5 November 2025

Your ref: AL/95/25/PL

Re: Belle Vue, Level Mare Lane, Eastergate, PO20 3SA

Proposed Plans and Elevations

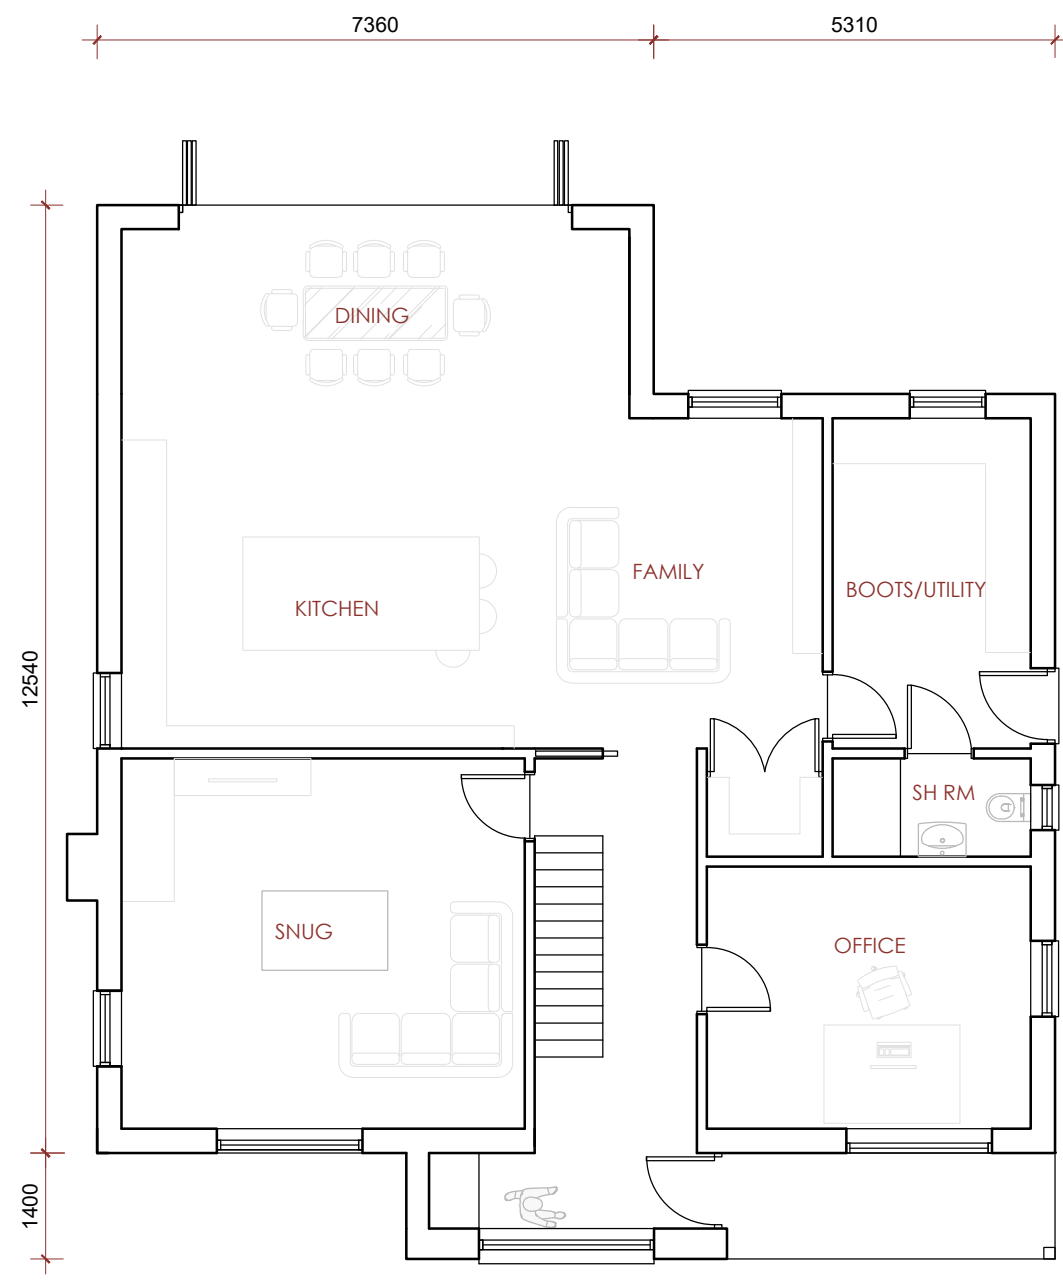
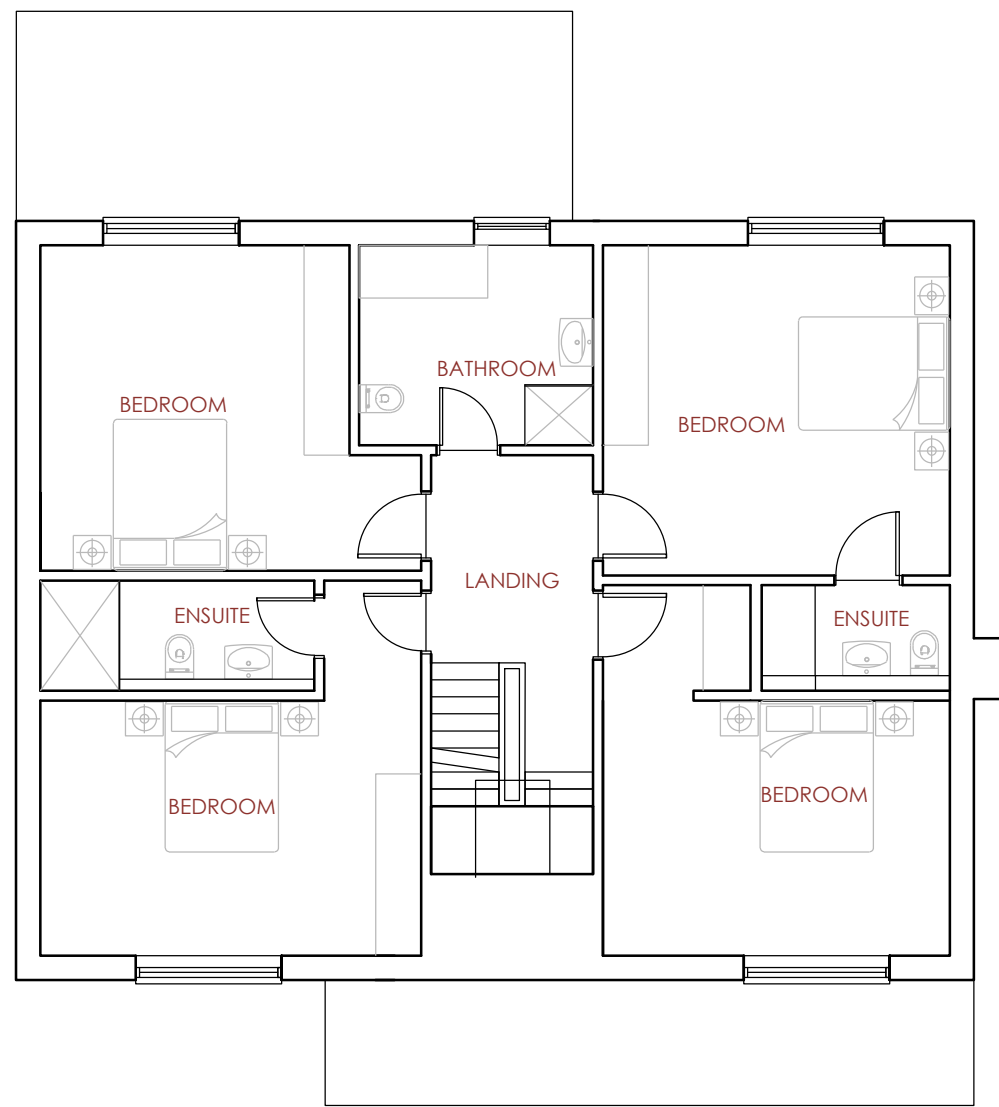
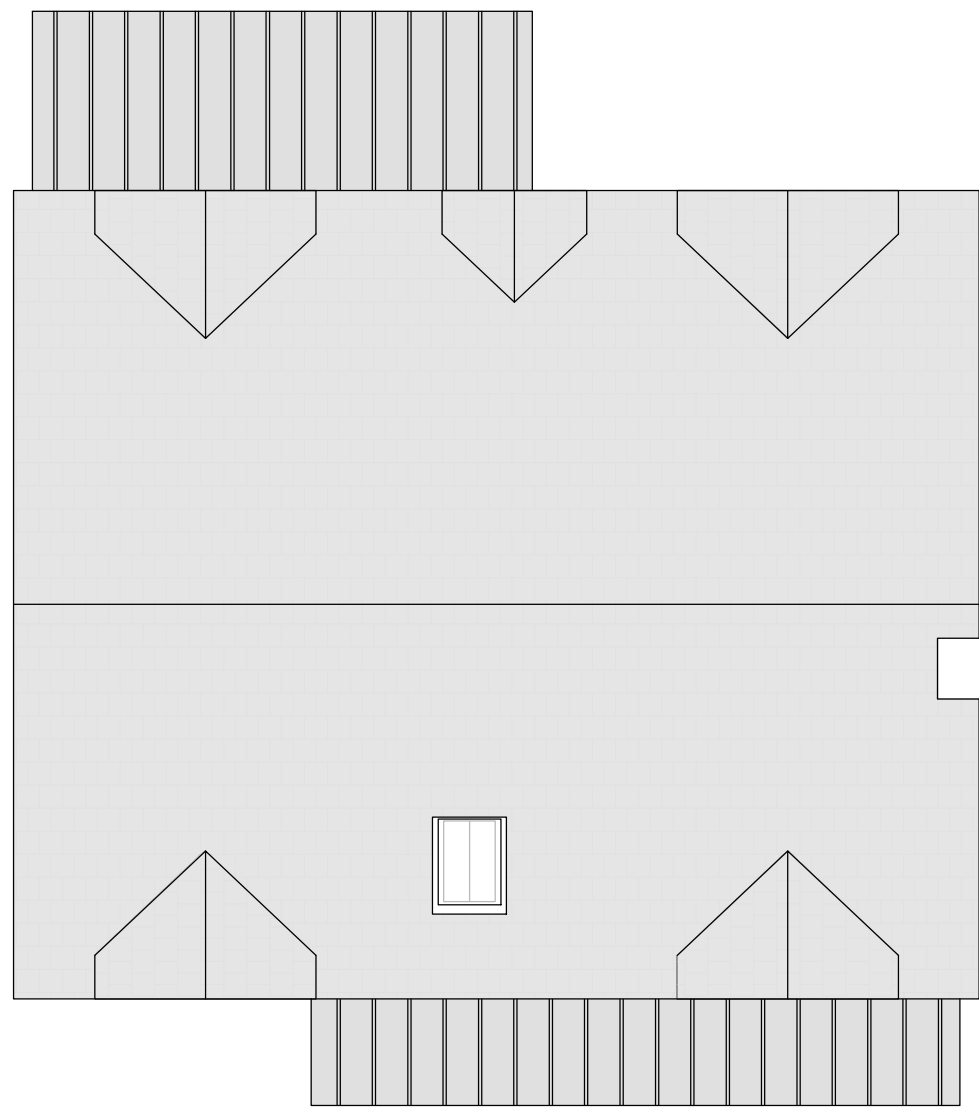
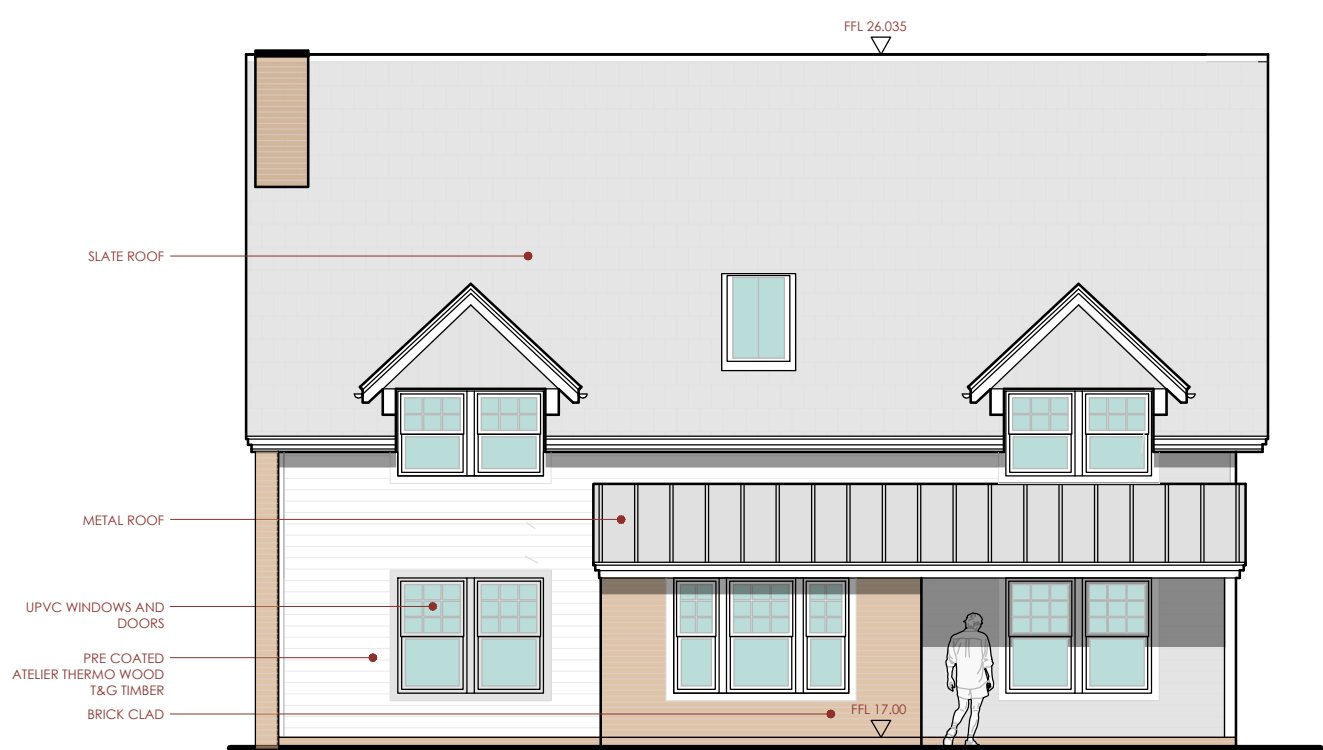
1. Chimney – This appears to be moving from side to side, some plans show it on the East Elevation and some on the West Elevation. It also appears to be out of proportion on the Ground Floor Plan.
2. Port Hole Window – This appears to be on the West Elevation, yet it does not show on the floor plans, is this to put natural light into a loft area? Is the glass going to be obscure?
